LEND LEASE

WESTPAC FIT-OUT DESIGN

ACCESS REVIEW

21st November 2012

drawing
LEVEL 01

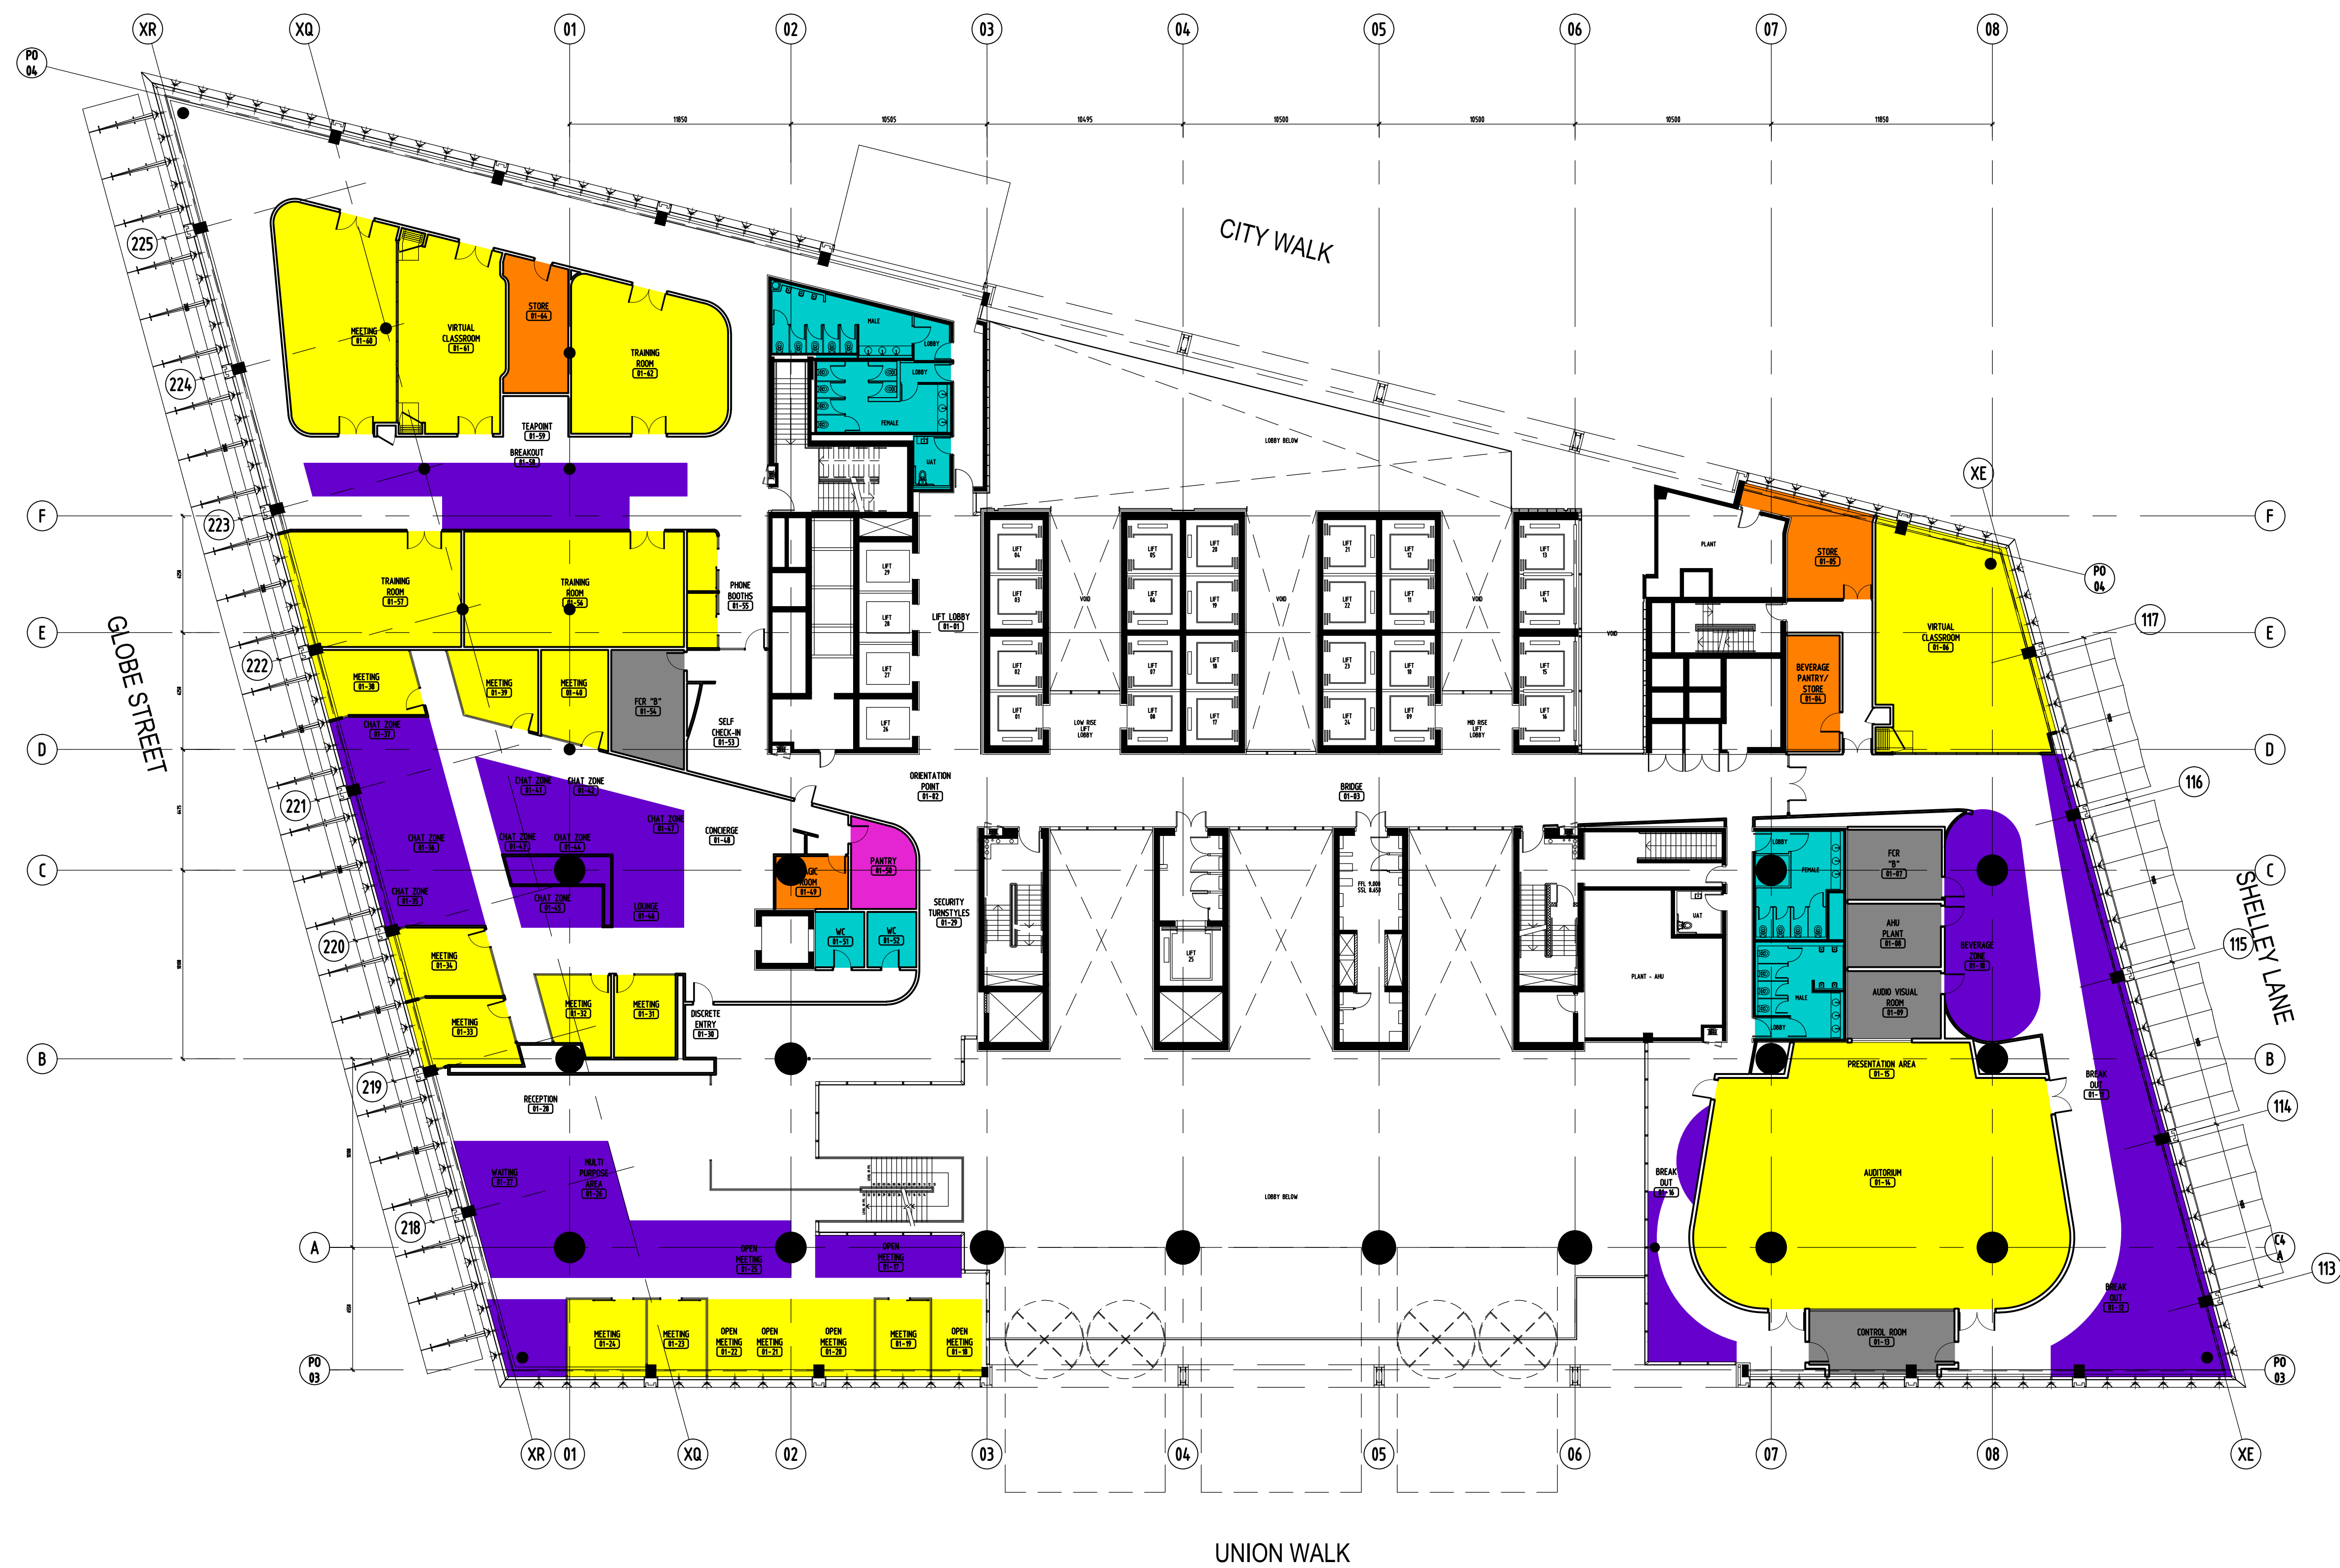
- (ii) Provide an accessible path of travel to the back of the Auditorium on level 01. Currently only accessible via stairs; a passenger lift may be required to ensure compliance with DDA Premises Standards.

- (iii) Provide 1 unisex accessible toilet near the level 1 Concierge desk, in accordance with BCA, Table F2.4 (a) and the DDA Premises Standards. This requires 2300mm x 1900mm clear area around pan with basin to sit outside the area (max. encroachment of 100mm at basin front) compliant with AS1428.1.

- (iv) Provide 1 accessible shower near the level 1 Concierge desk with minimum dimensions 1160mm wide x 1060mm long in accordance with the AS1428.1. Ensure there is an unobstructed circulation area of 1600mm x 1400mm outside the shower cubicle. Alternatively, ensure a combined circulation area of 1600mm x 2350mm compliant with AS1428.1:2009. Accessible shower requires:

- (v) Ensure at least 1 additional toilet cubicle in that area is to be designed as an ambulant cubicle in accordance with AS1428.1:2009 and the DDA Premises Standards.

- (i) The following doors require greater clear width to ensure 850mm min. (generally 920mm door leaf) to comply with AS1428.1:
 - Level 01, UAT hinged door (grid ref. C07): currently 830mm;
 - Level 02, UAT hinged door (grid ref. C07): currently 820mm; and
 - Level 02, stair dual-hinged entry door (grid ref. A02): currently 820mm.
- (ii) The following hinged doors require greater latch side clearance to ensure 530mm min. width on latch side (door opens toward user) to comply with AS1428.1:

- (i) Provide an accessible path of travel to the back of the Auditorium on level 01. Currently only accessible via stairs; a passenger lift may be required to ensure compliance with DDA Premises Standards.

It is currently unclear from the drawings if this area is to have tiered seating. No wheelchair seating spaces have been identified.

- (i) Provide 5 wheelchair seating spaces within the auditorium with at least 1 single space and no less than 1 group of 2 spaces.
- (ii) Ensure wheelchair seating spaces are designed in accordance with AS1428.1:2009, fig.54.

scale: 1:100 (A0)
 drawing: LEVEL 04
 DA PLAN
 project number: 111689
 drawing number: DA04
 revision: D

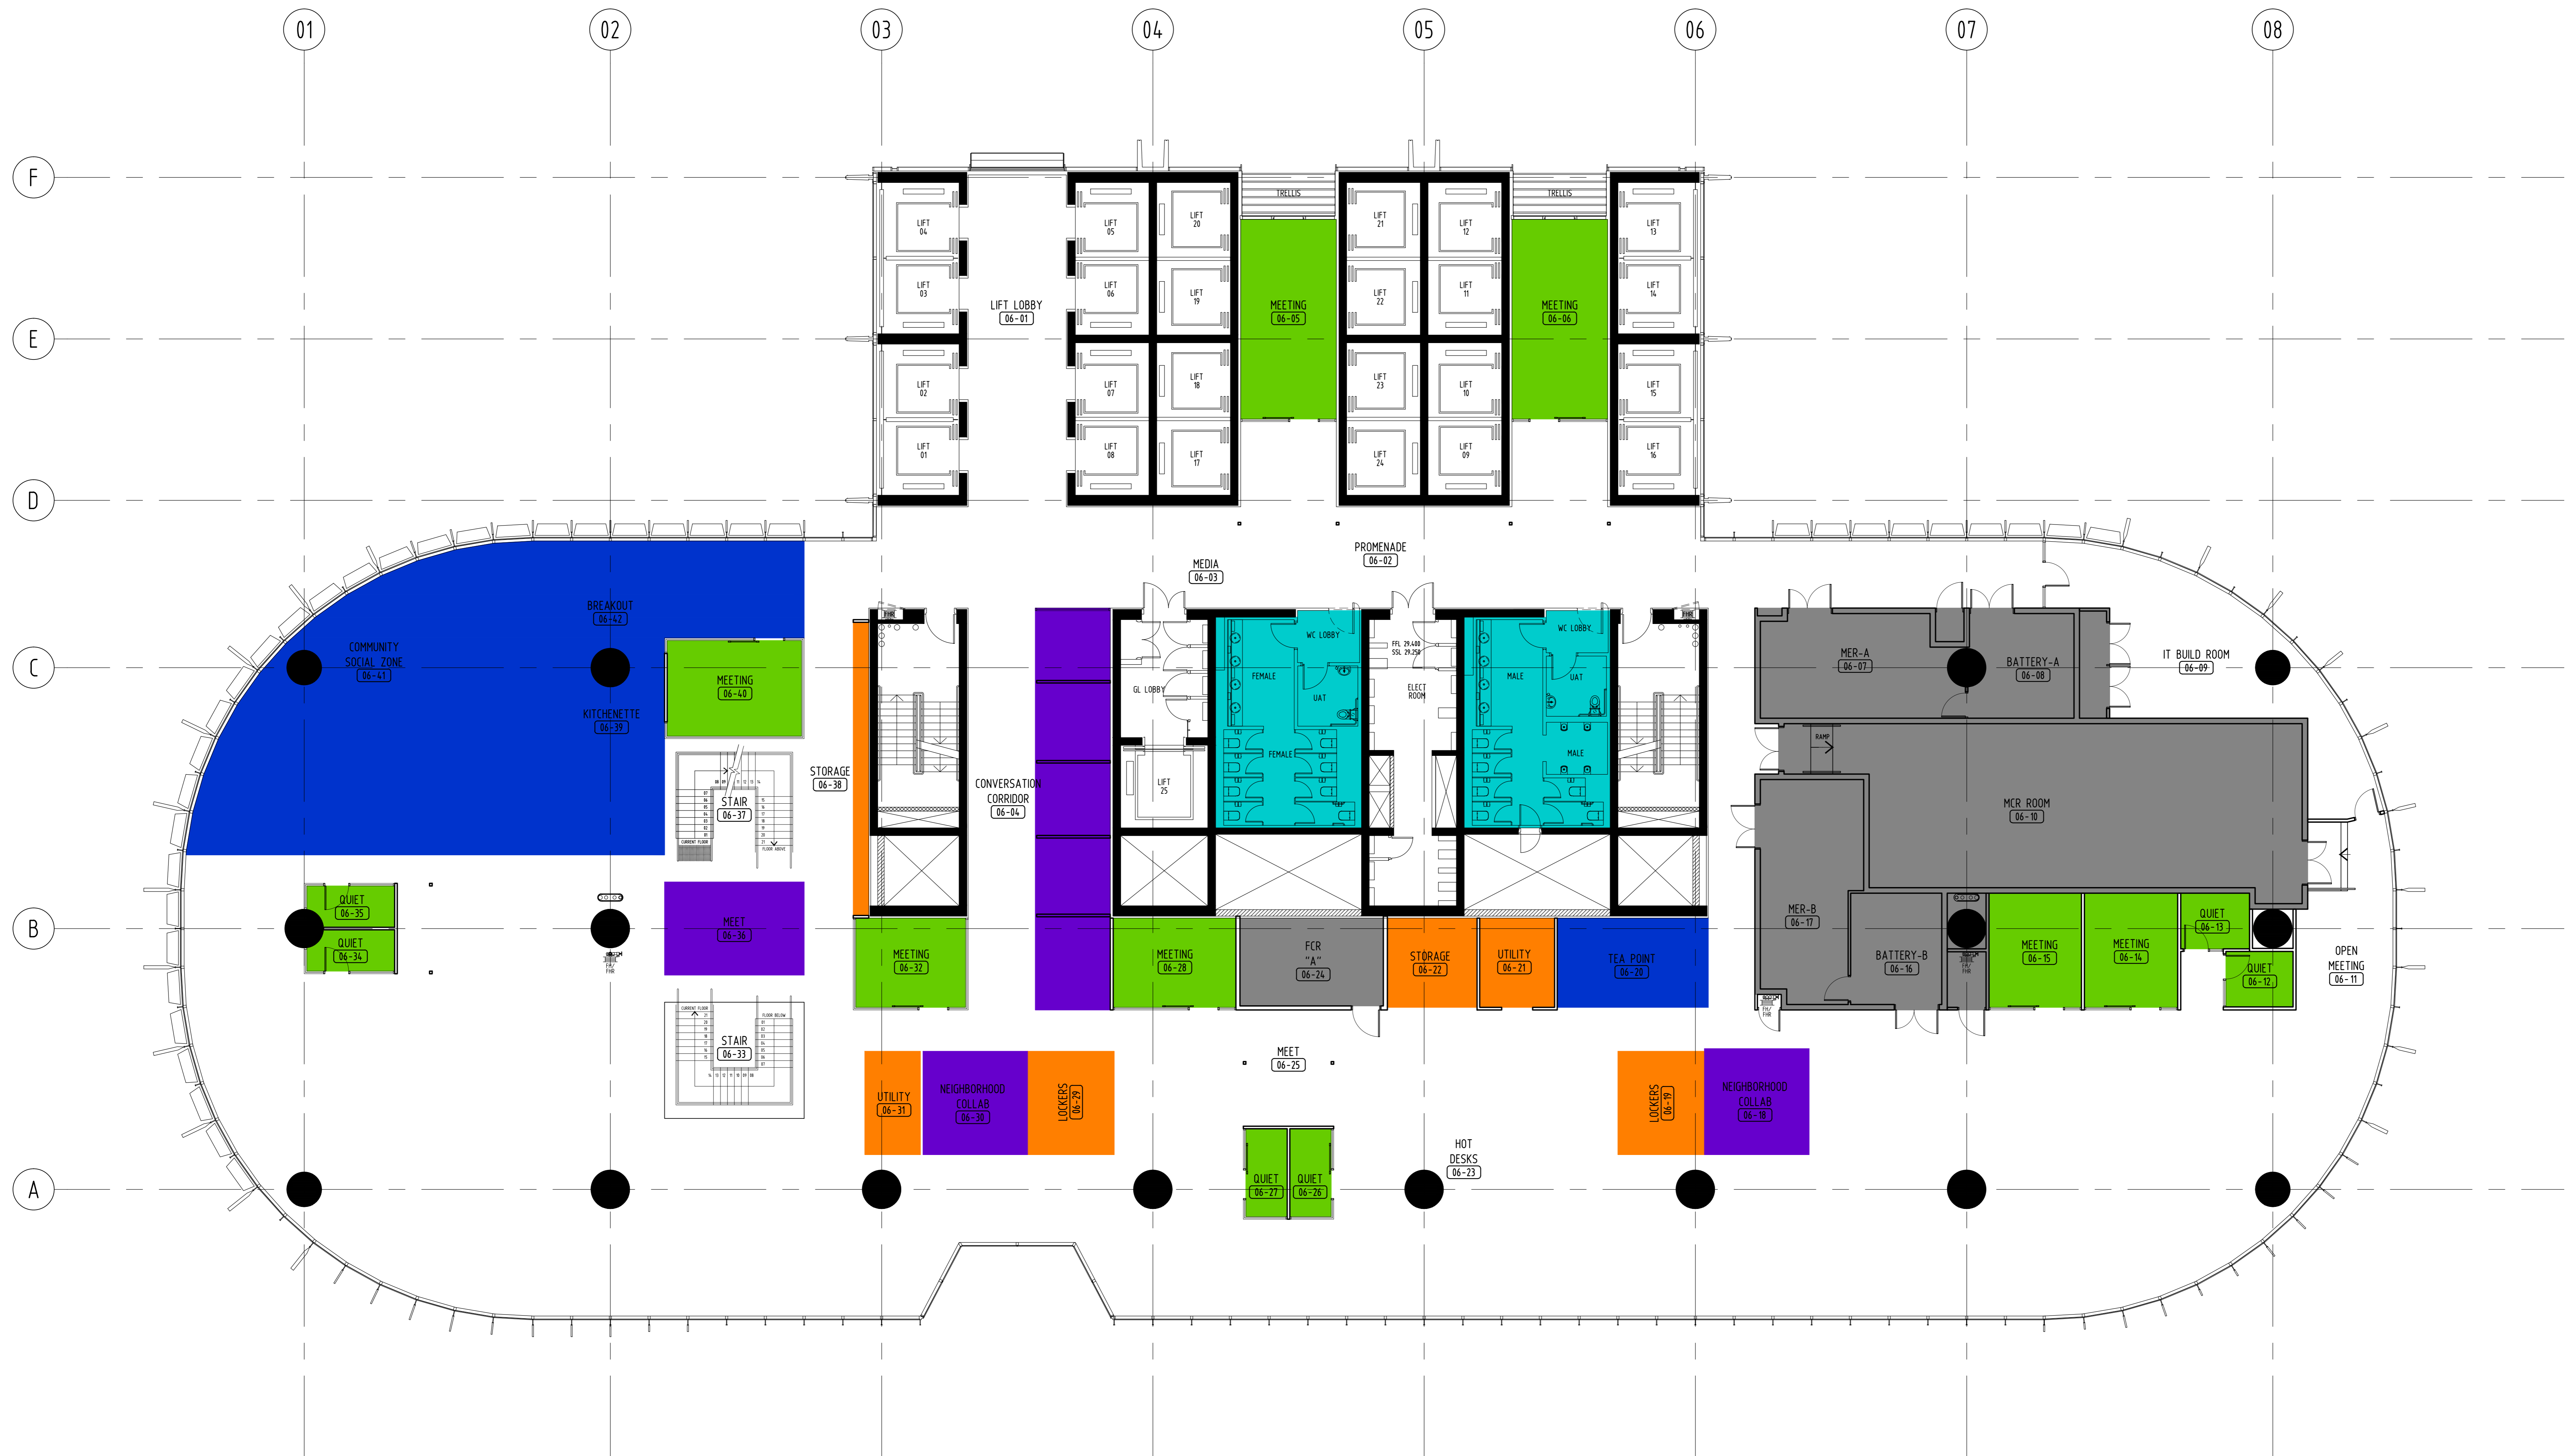
- (i) Ensure quiet rooms (levels 02 and 04-26), have suitable turning areas of minimum 1550mm diameter, areas after furniture has been placed to allow a person in a wheelchair to perform 180 degree turns compliant with AS1428.1:2009.
